RE: HIGHVIEW FARM

Metis have completed their second review of application 39755/APP/2023/652 - Highview Farm, Newyears Green Lane. Please refer to the comments below.

BUND SECTIONS

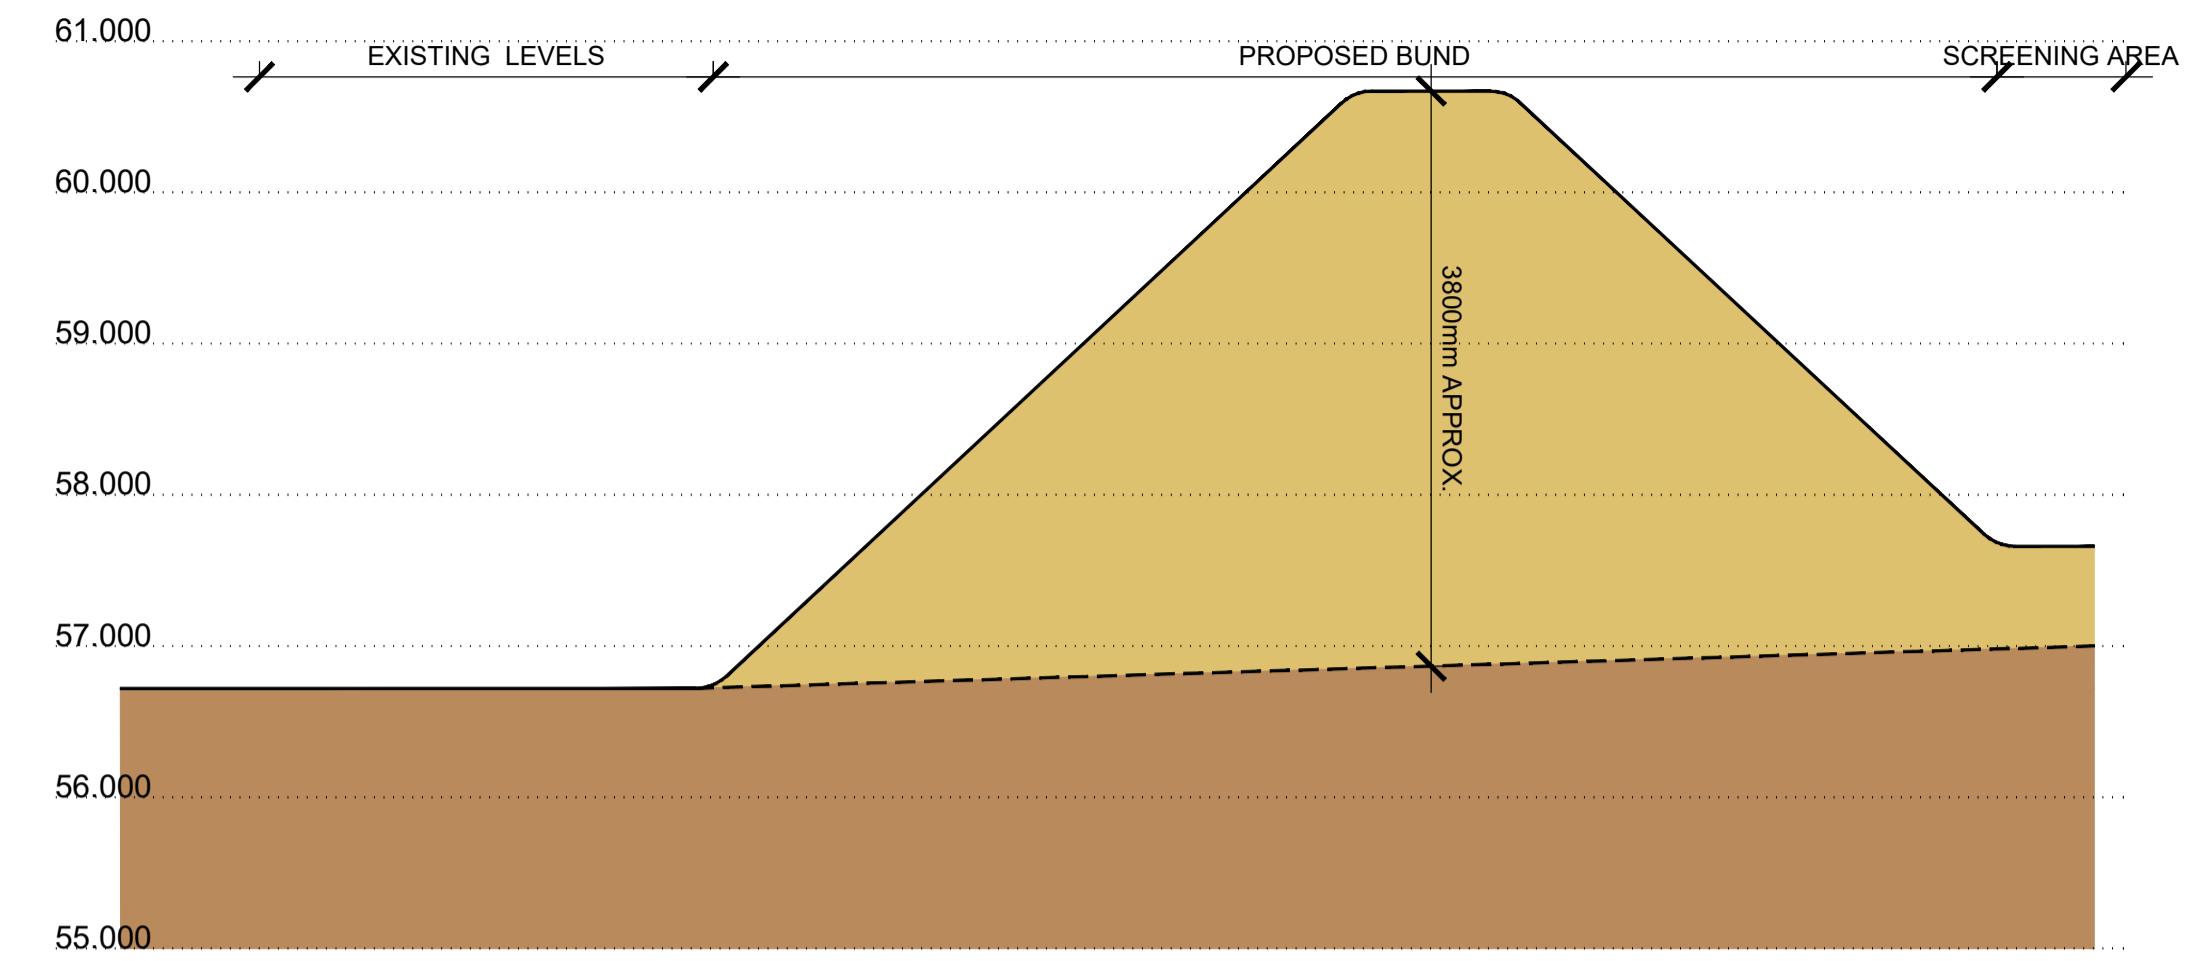
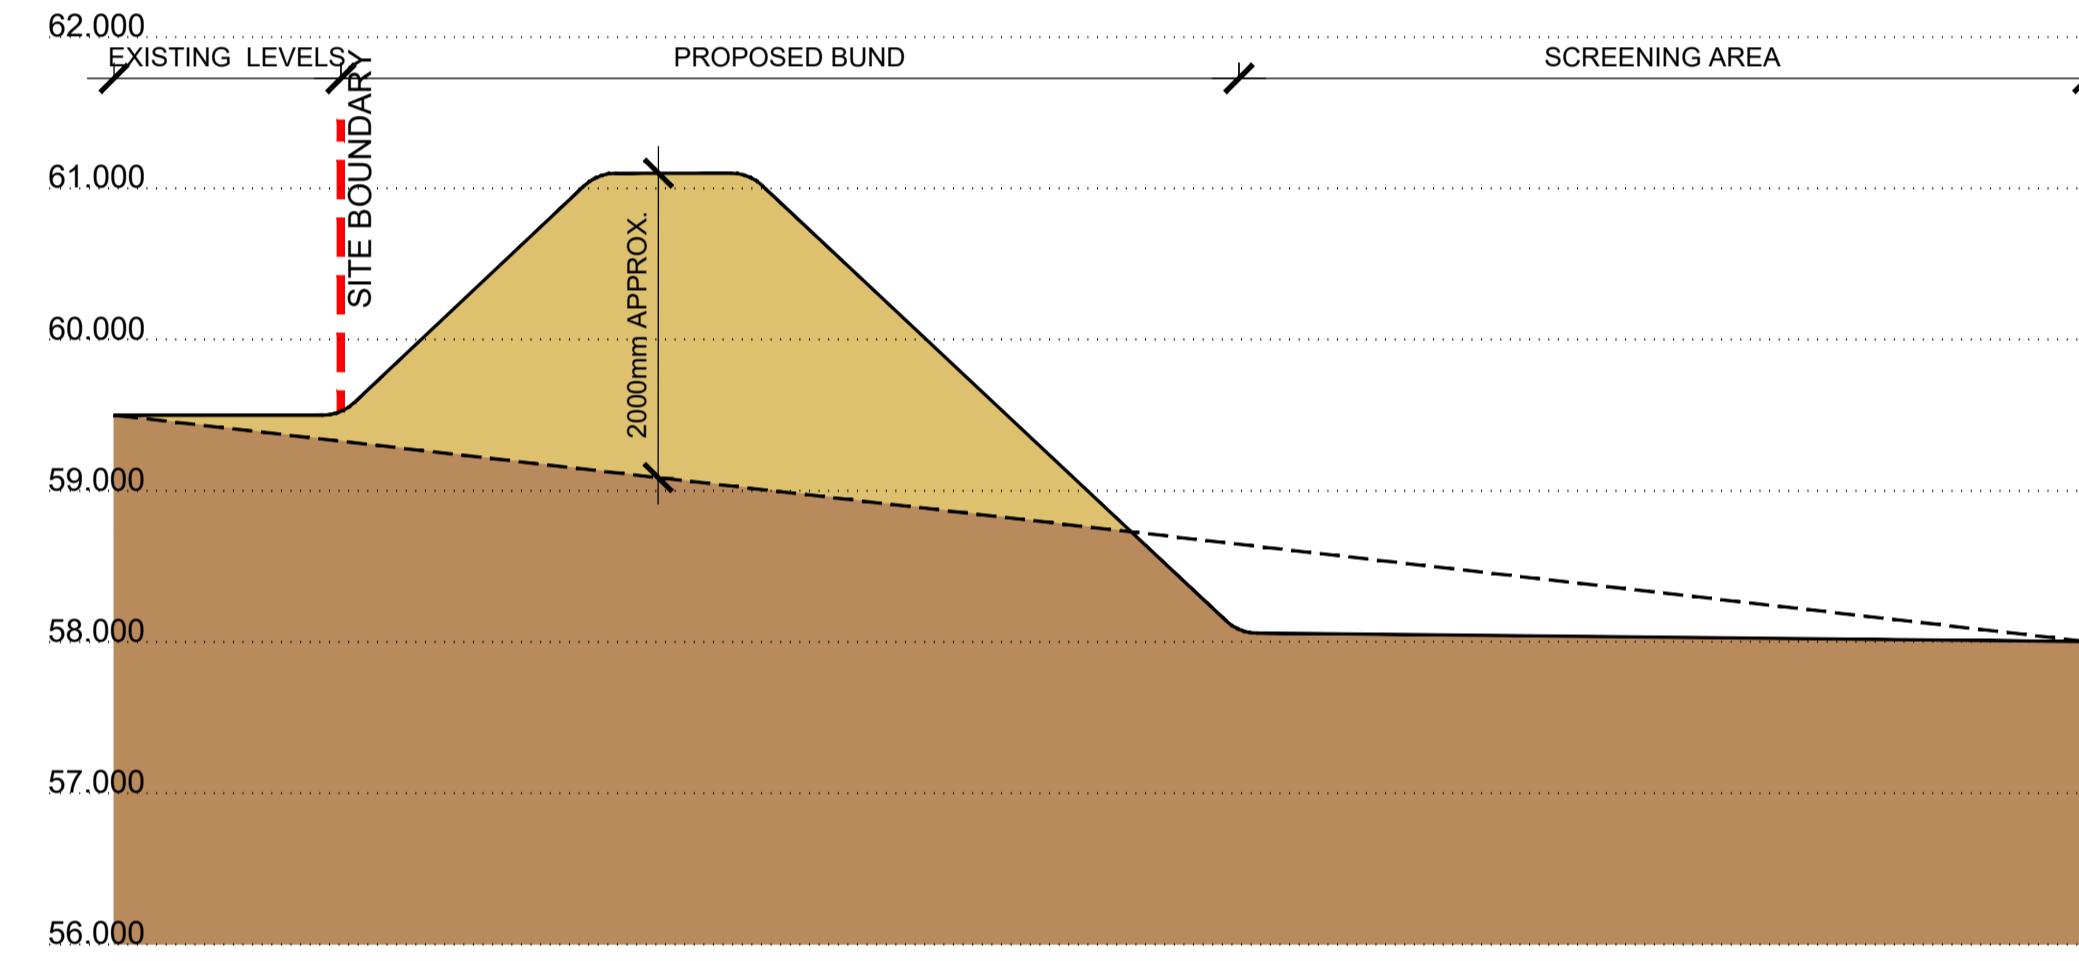
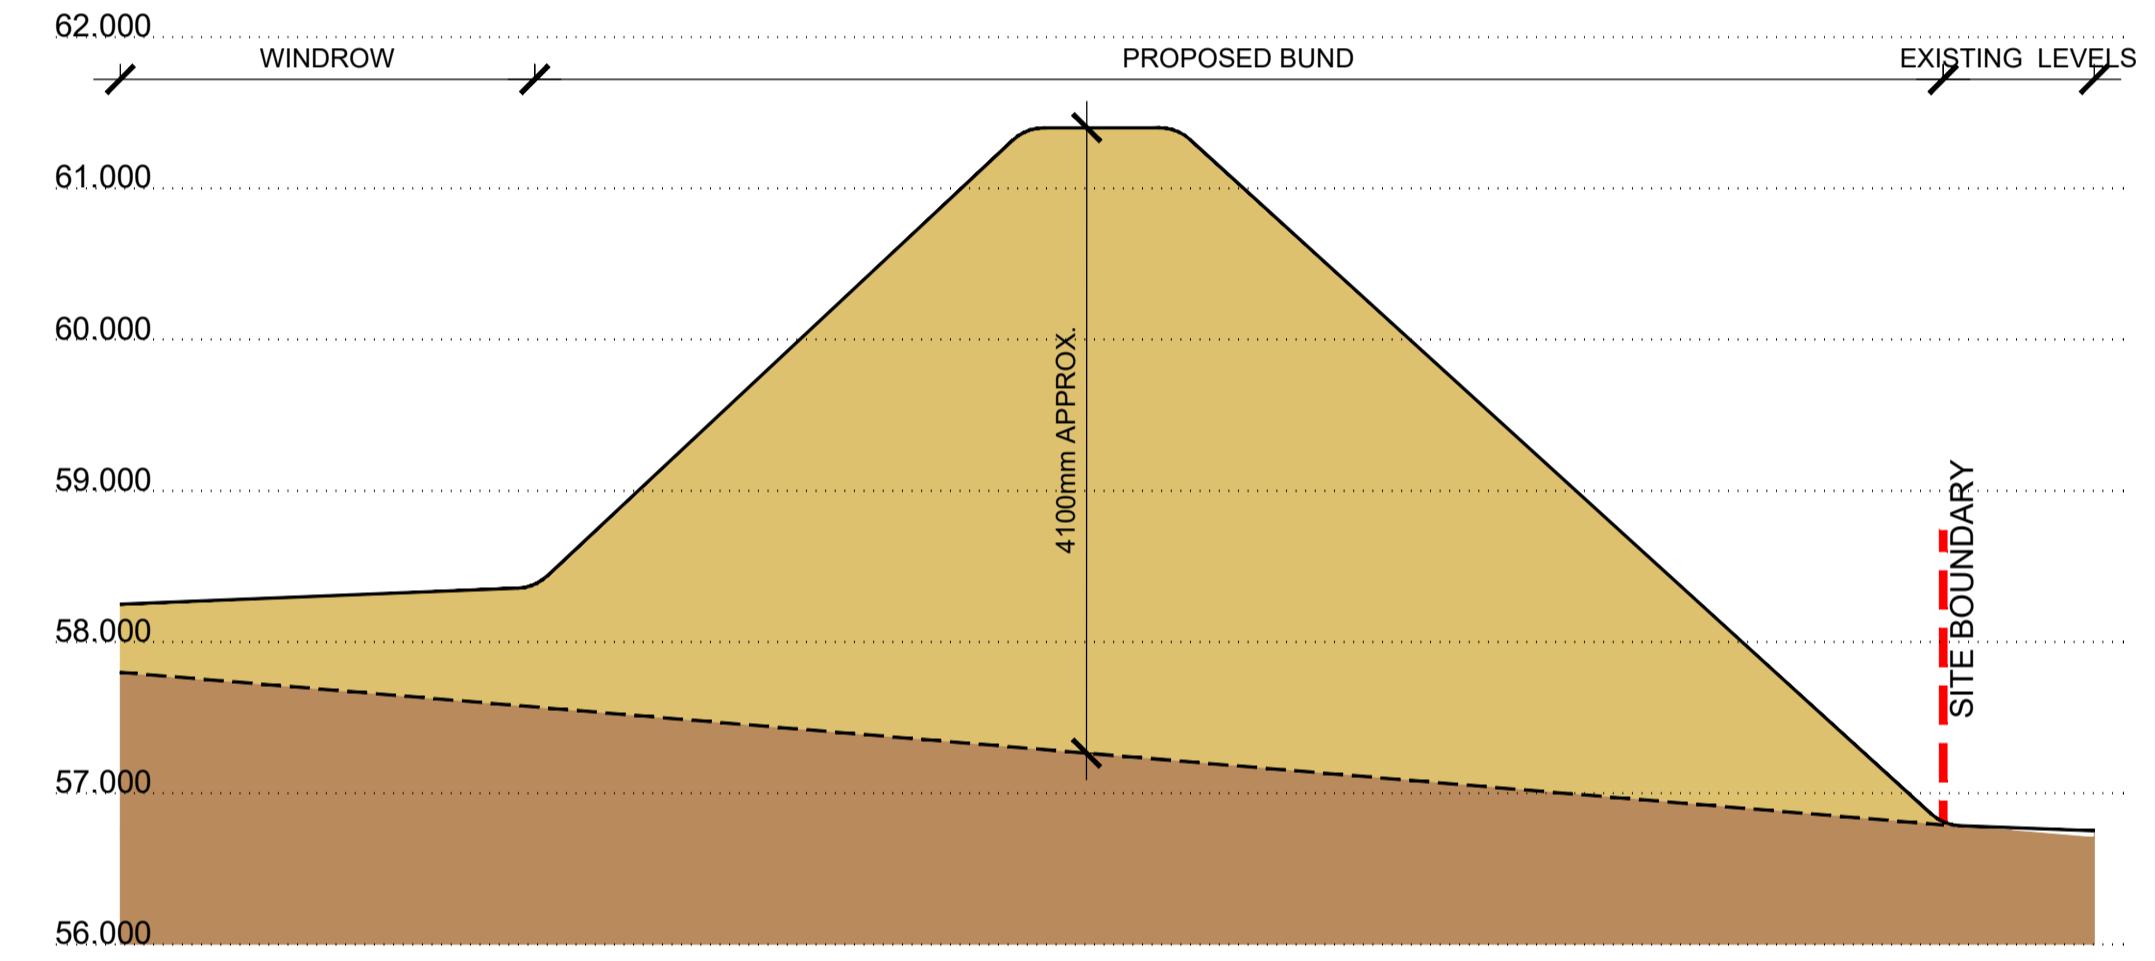
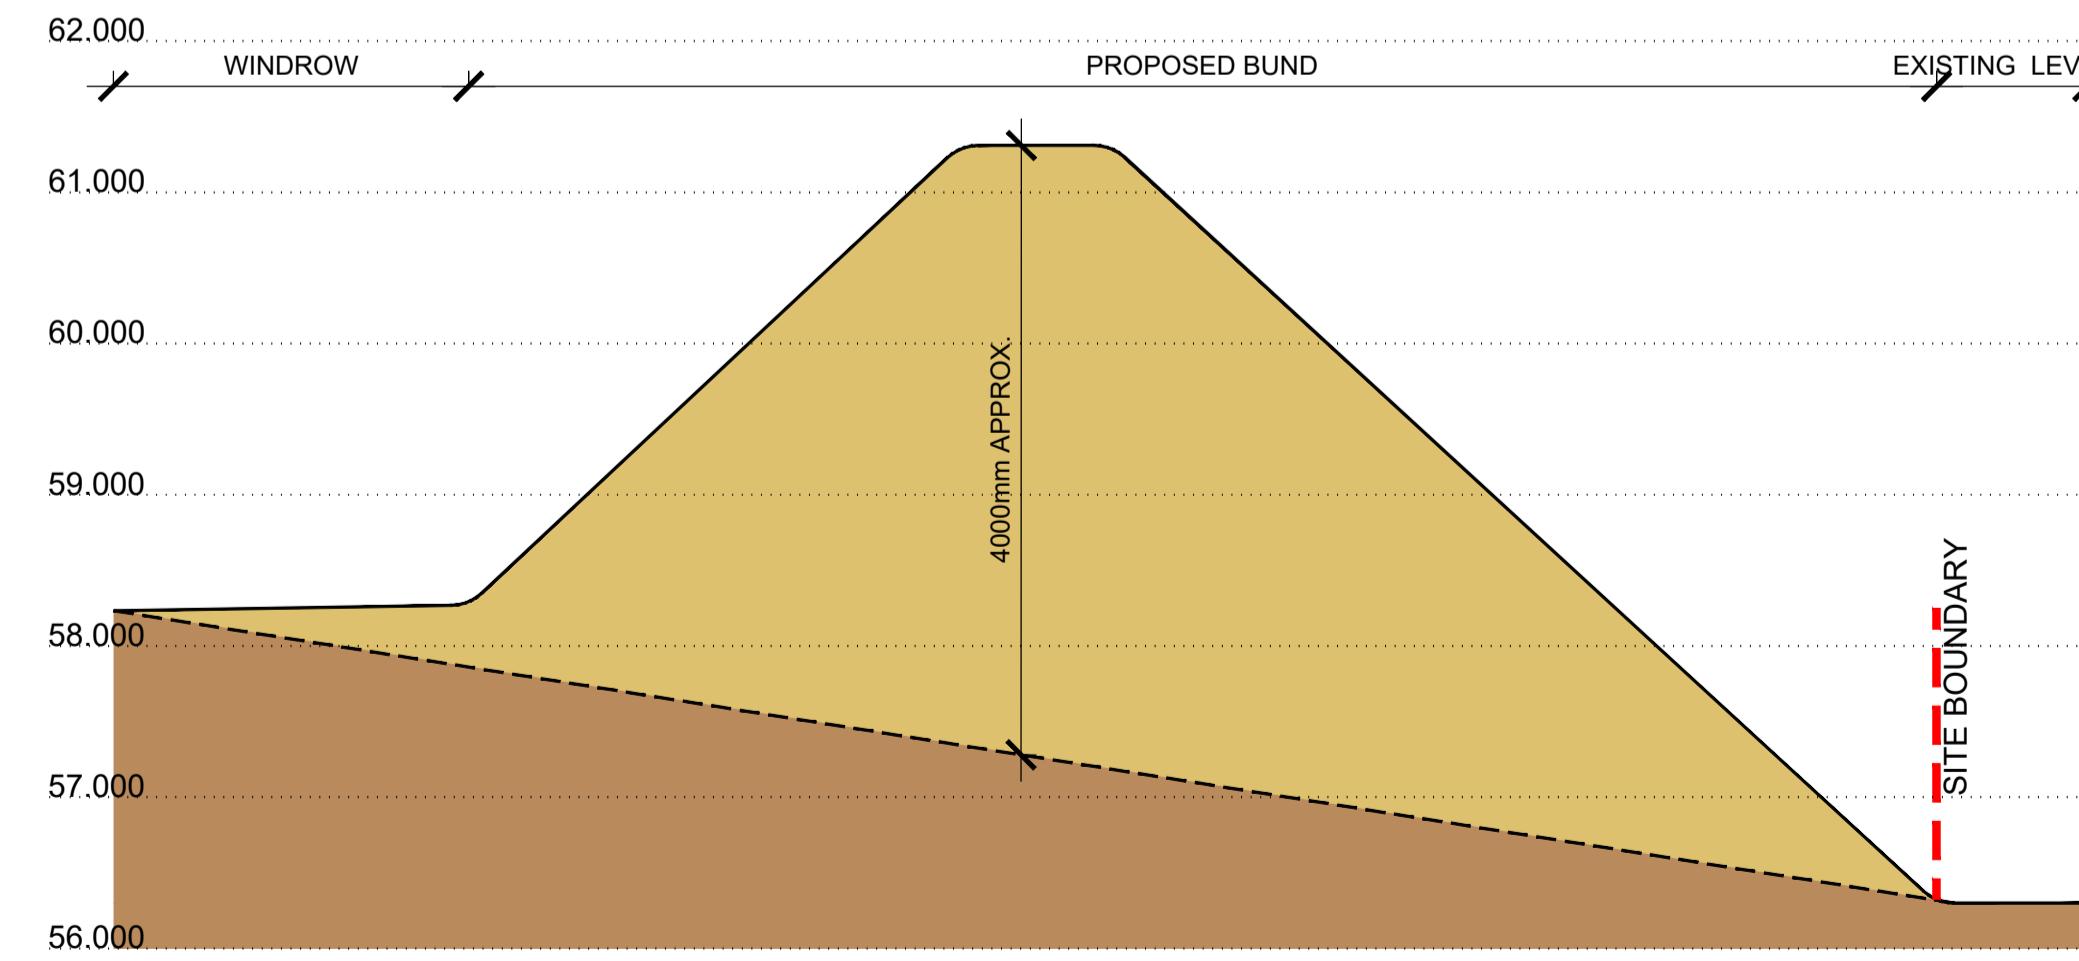
- The applicant has not confirmed what the storage volume of 10,000m³ in the calculations includes, as only 2,297m³ has been stated as being proposed within the water tanks and bunds.

The storage includes c.2,297m³ in the tanks and c.7,703m³ on the surface of the hardstanding behind the site bunding, which is approx. 3m high. This is to show that the 1in100+CC storm event can be stored with no offsite flooding. The water would be spread onto the compost as confirmed previously. It is also worth noting that the site bunding prevents over 22,900m³ of volume from leaving site.
